Application for Removal or Variation of a Condition following Grant of Planning Permission or Listed Building Consent

Single-storey extension; two storey extension to Salterns Mead; demolition of no. 2 Kingsfield adjacent with construction of replacement dwelling

22/10899

Amendments to approved Drawings involving the following:

Drawing title:
**Proposed Ground Floor
Plan**

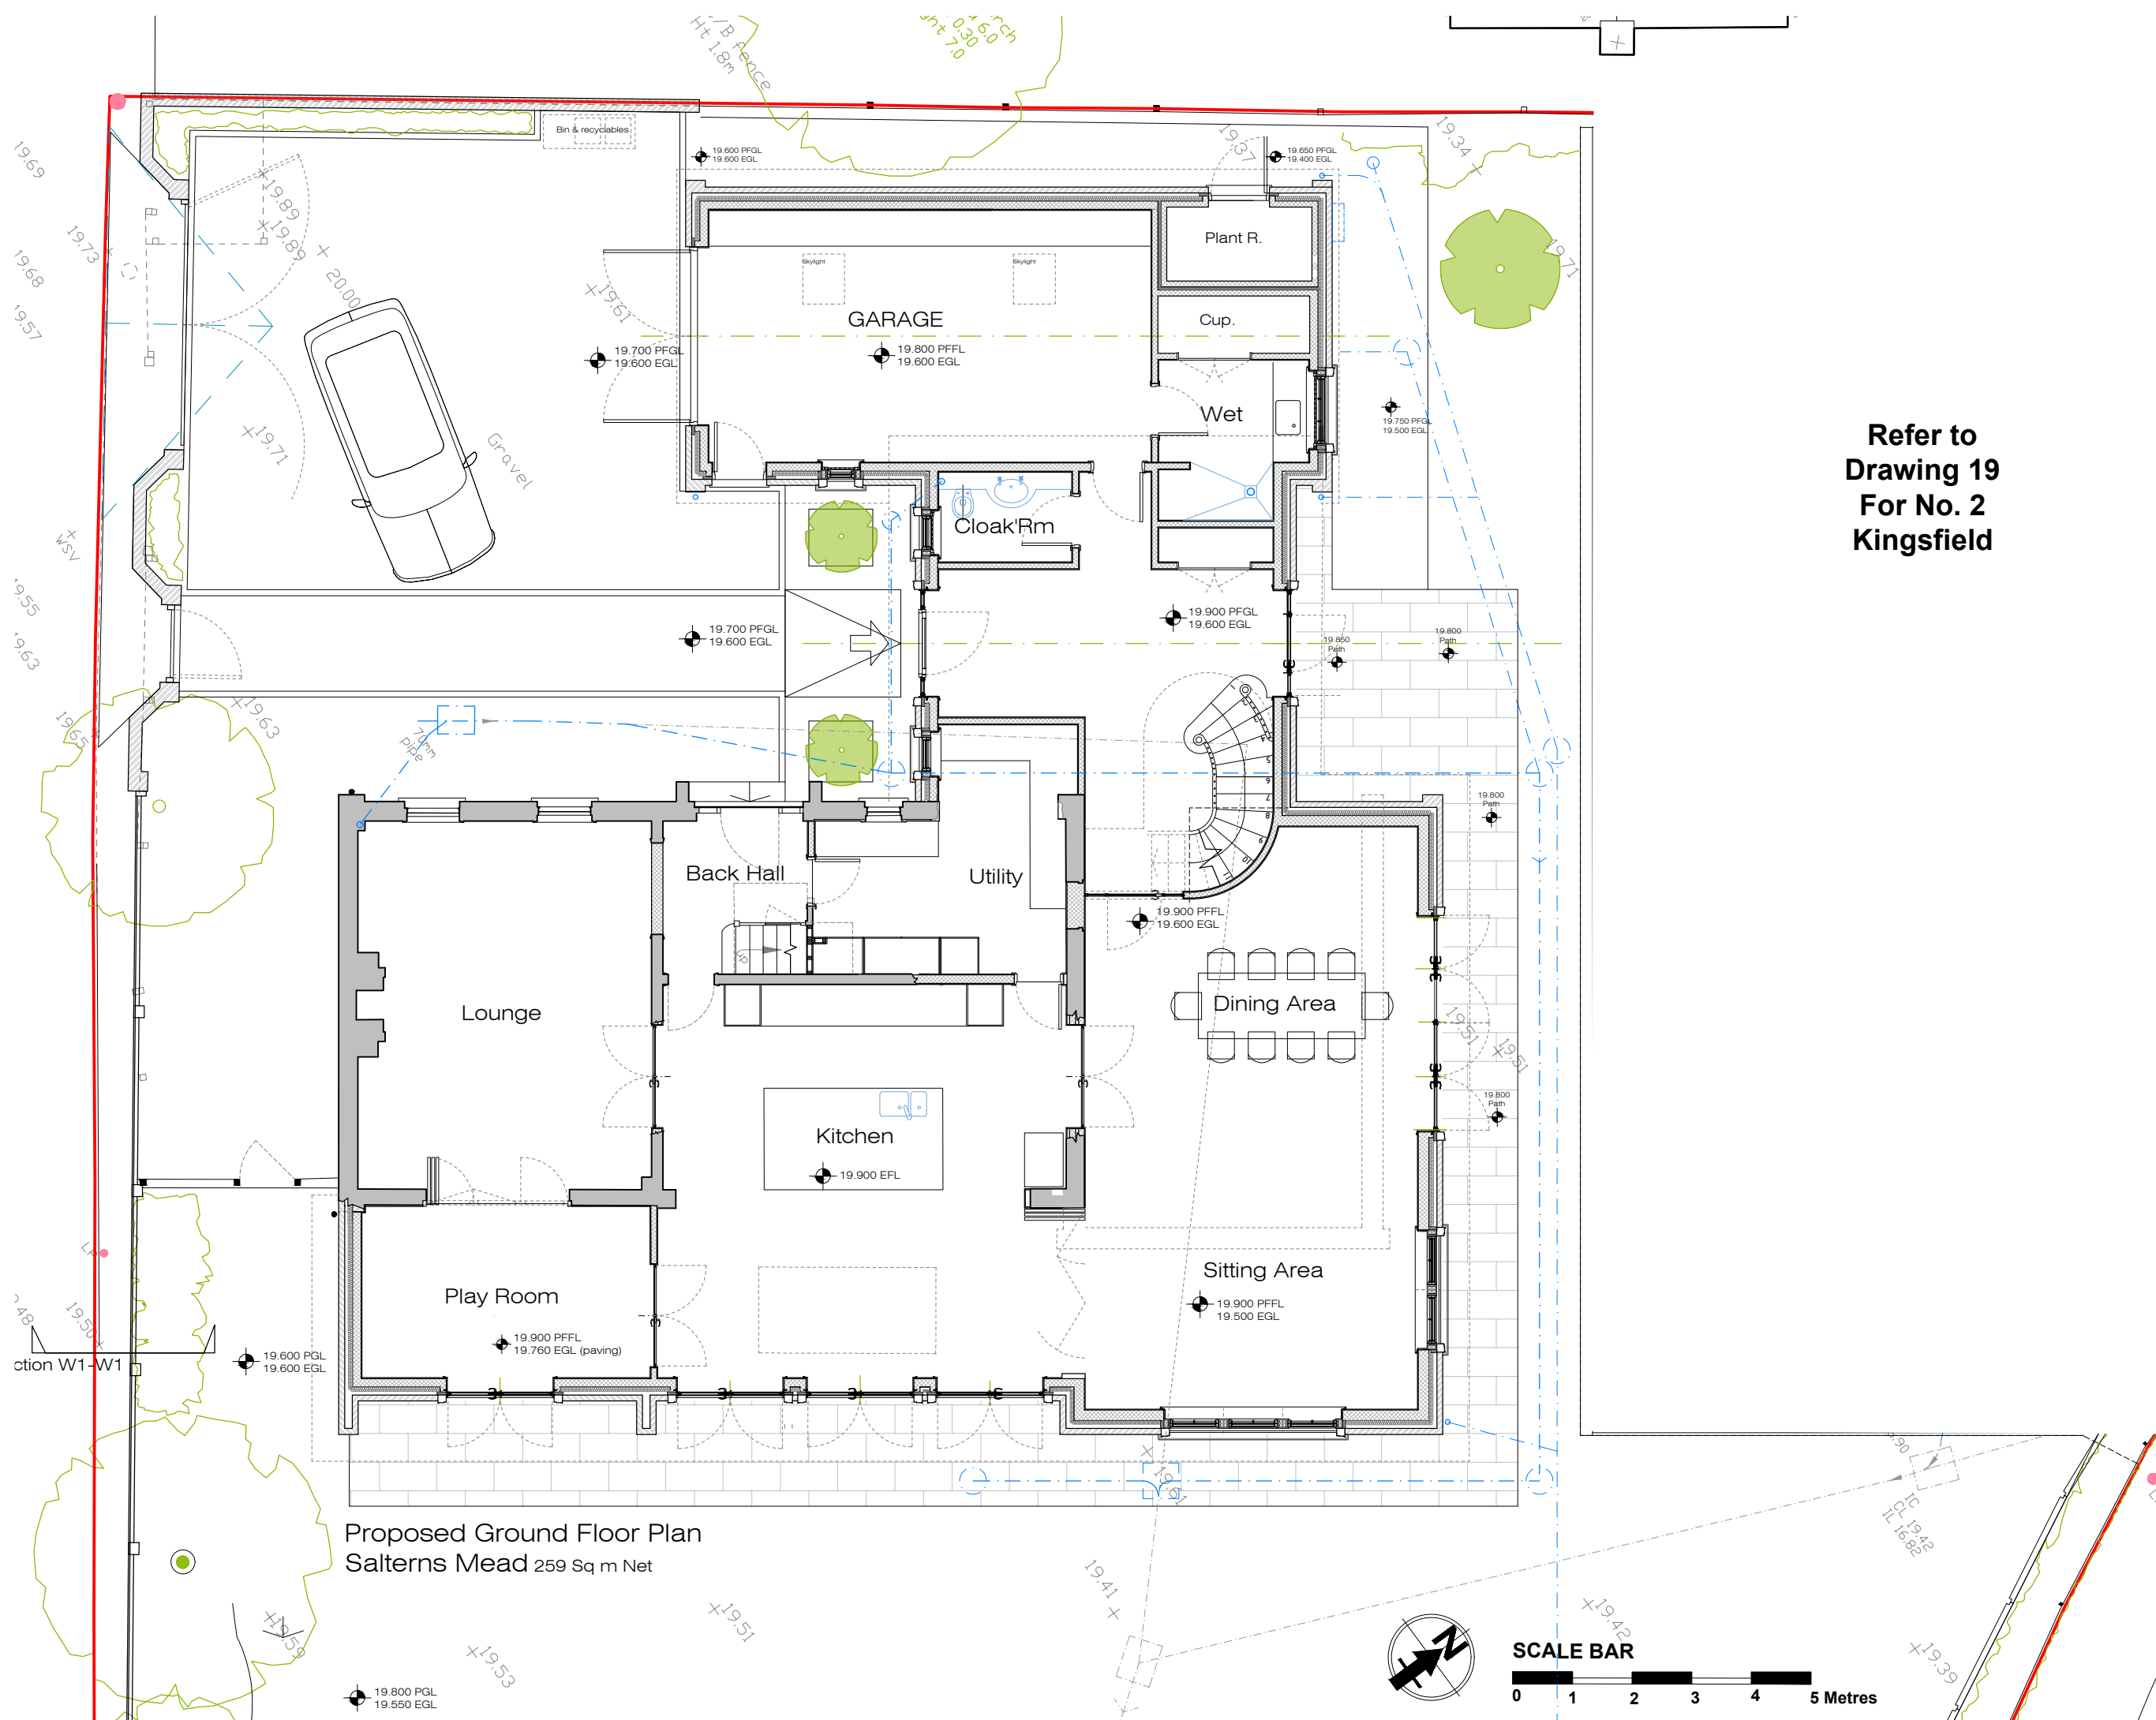
Ground Floor infill extension to southern corner of no. 47 Salterns Mead extending to garden not to highway.

Drawing title:
**Proposed Boundary Walls Details
& Section WW**

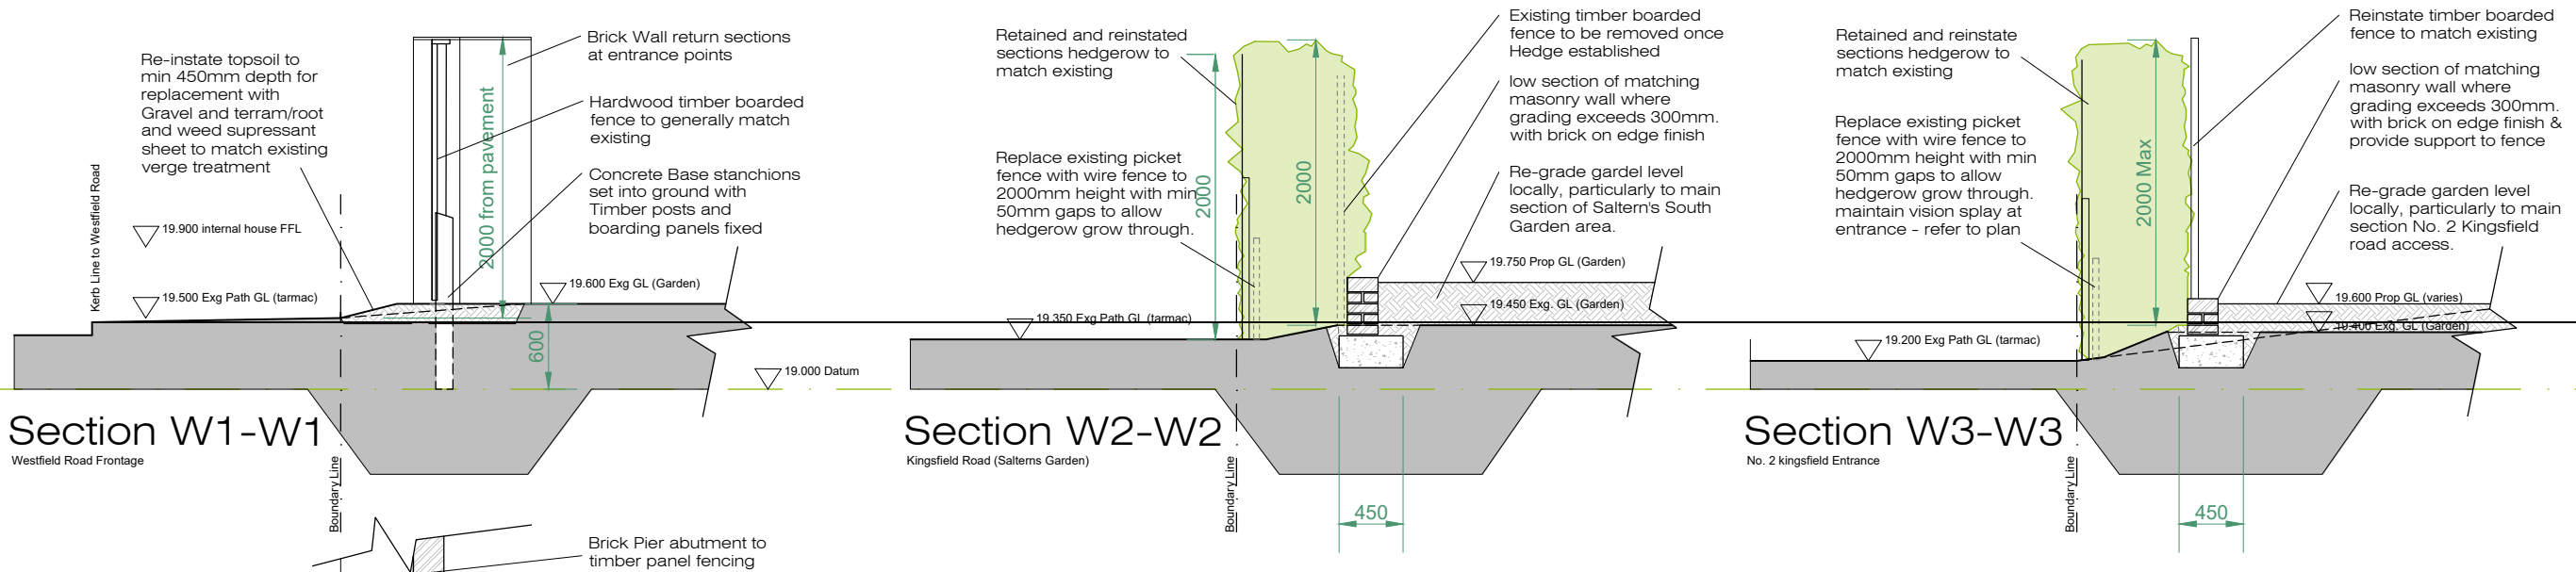
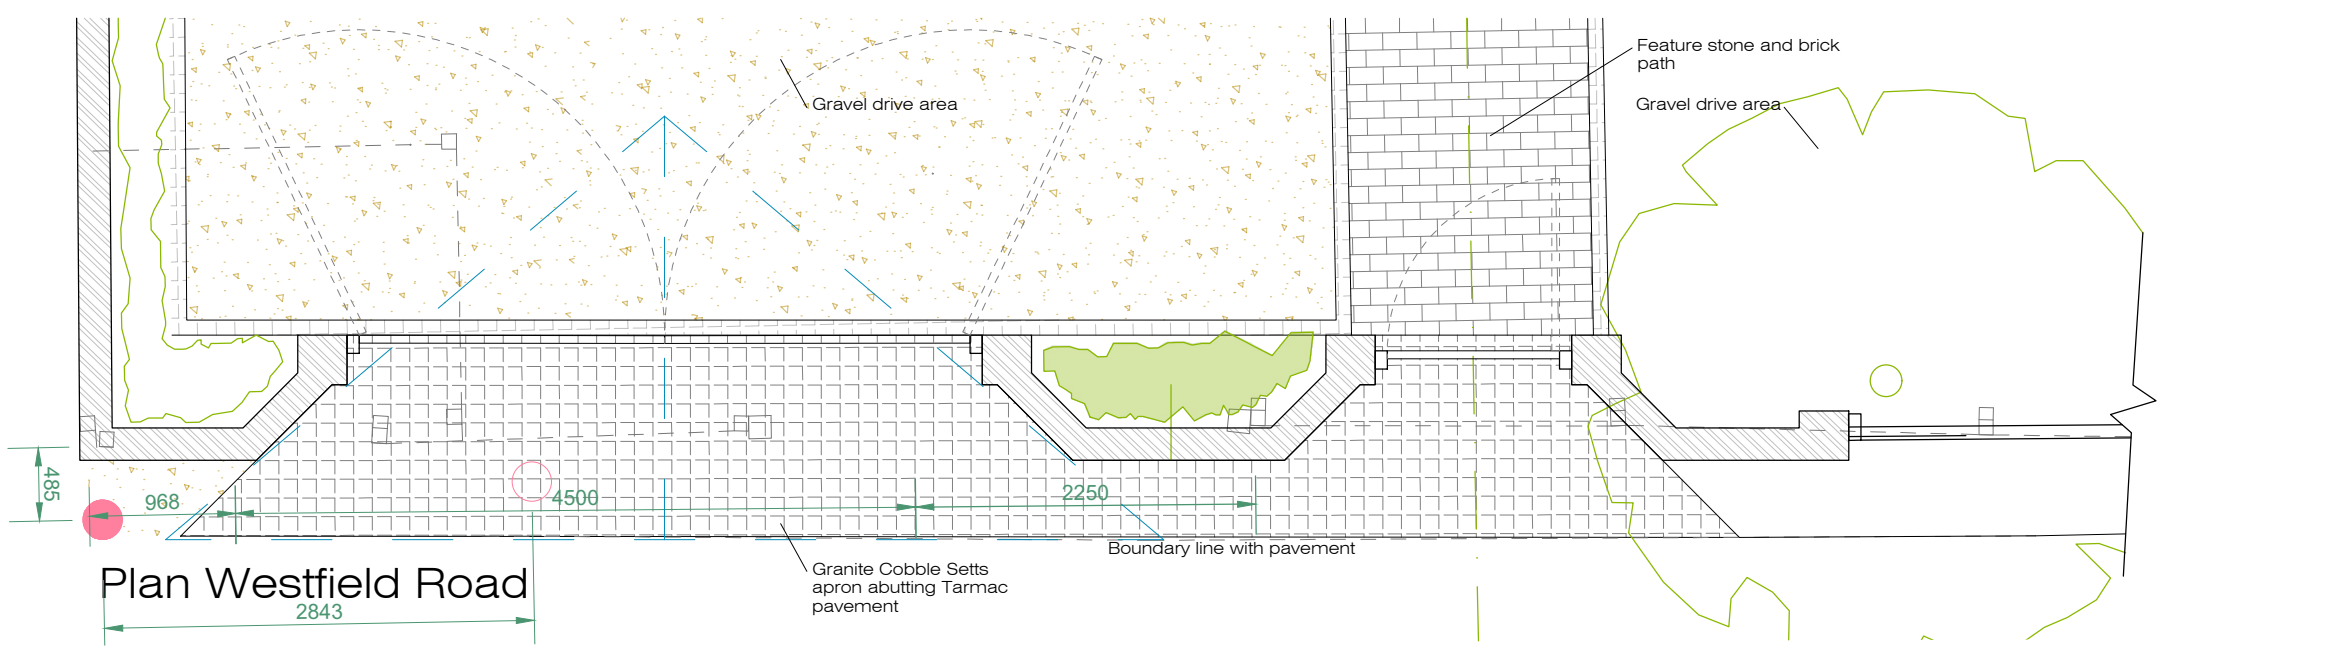
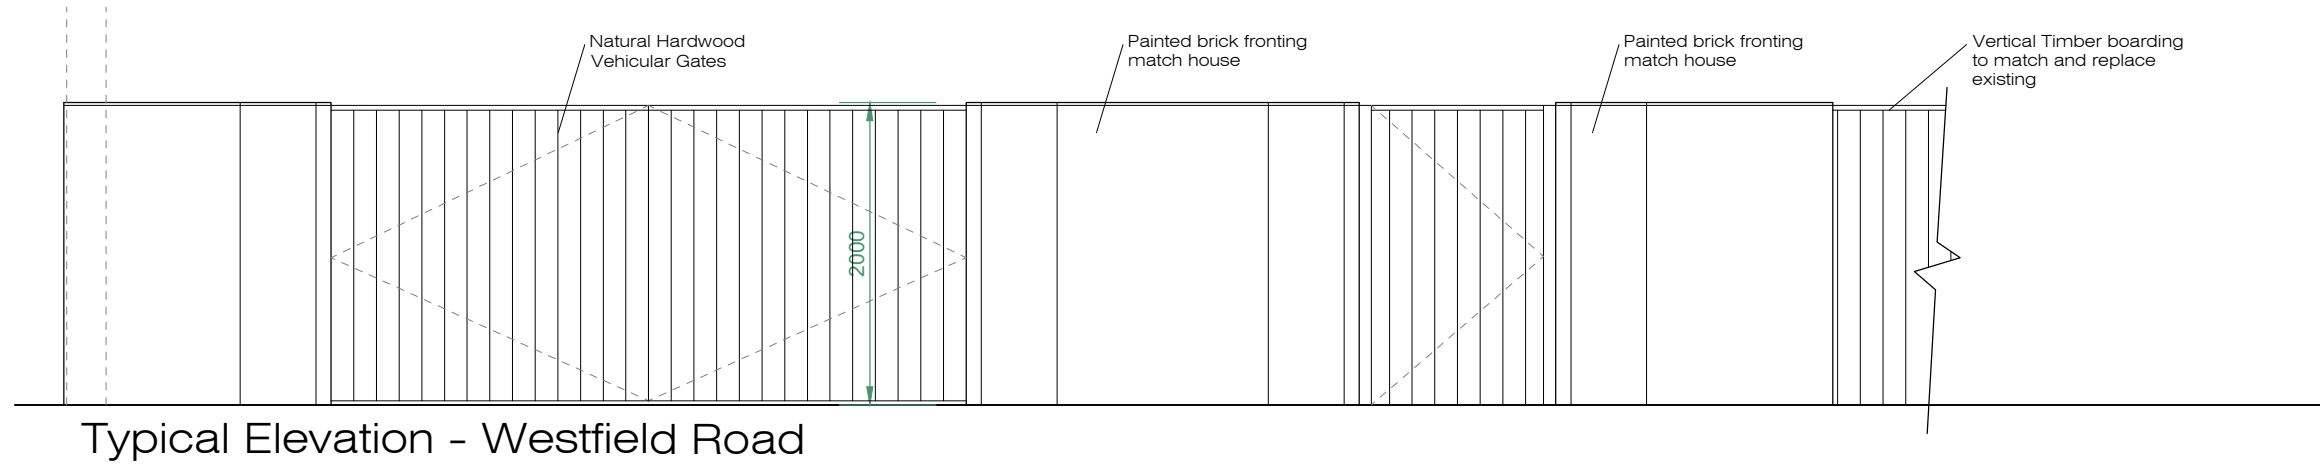
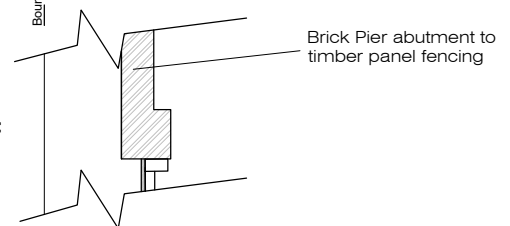
Landscaping alternations for both house entrances updated following detailed design also embodying condition no. 7 item with detail Drawing HMS 55 / 28

Drawing title:
**Existing & Proposed
Elevations 2**

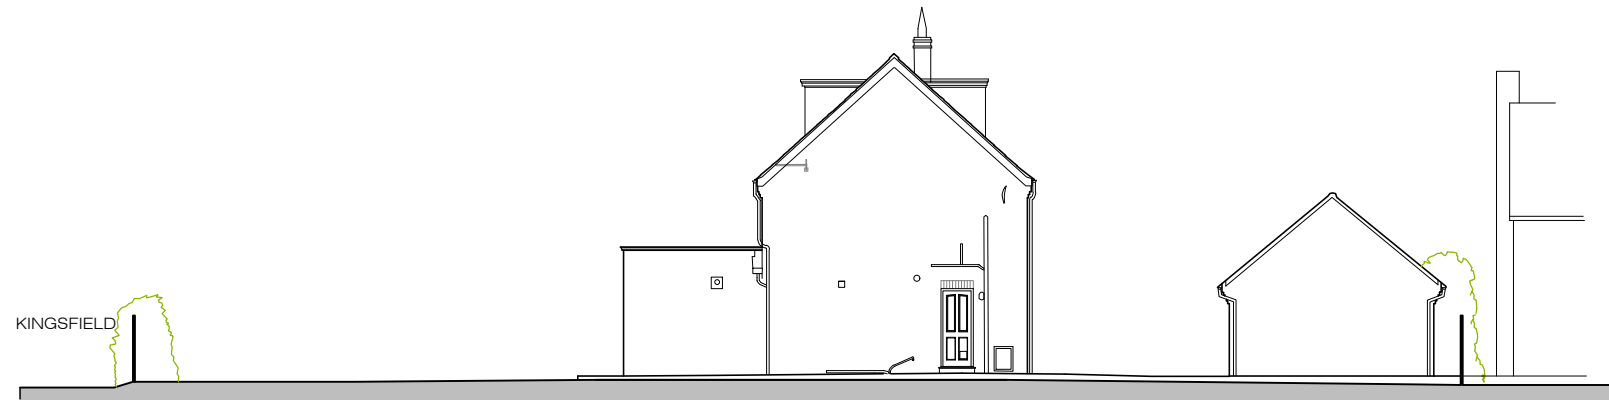
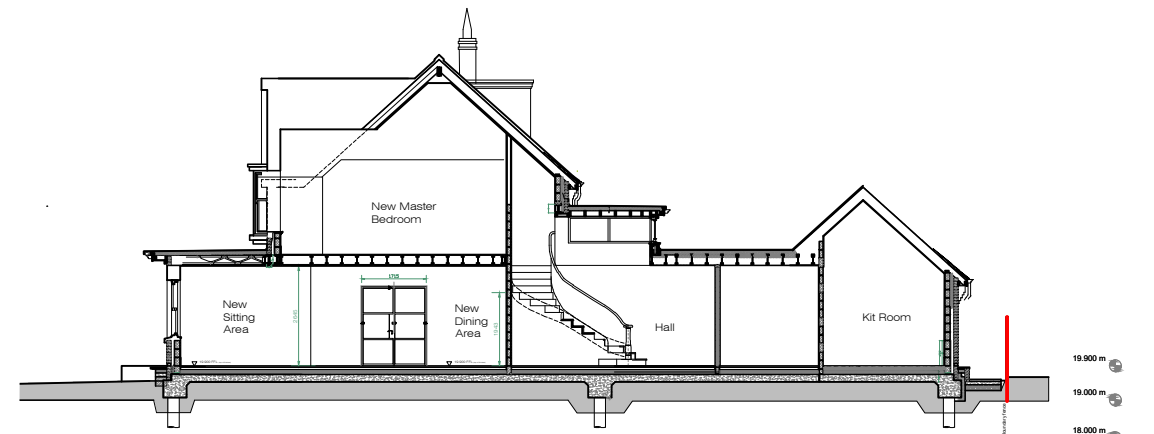
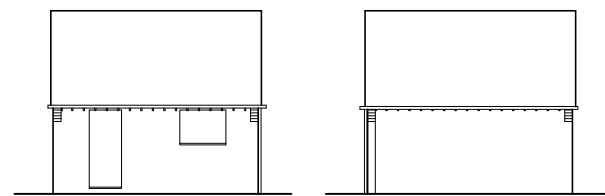
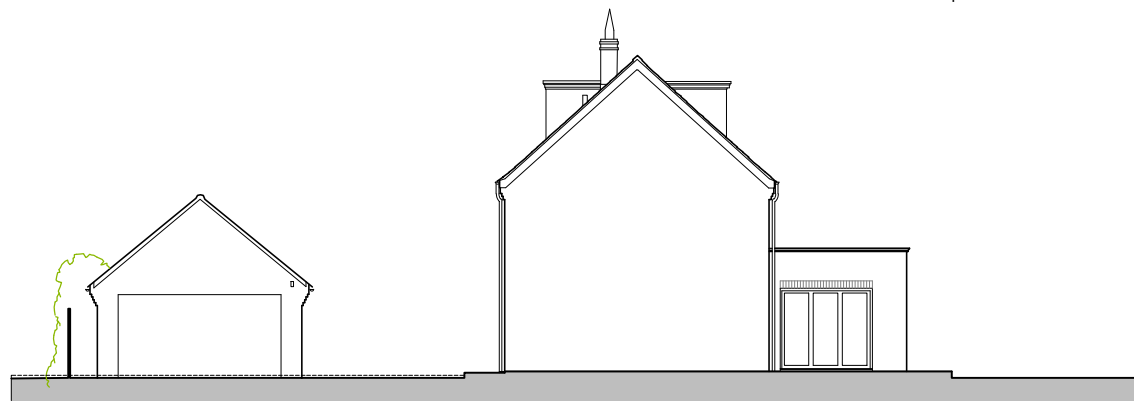
additional bathroom window to South eastern façade to serve shower room, minor adjustments to window positions on garage to suit internal arrangement, one skylight omitted.
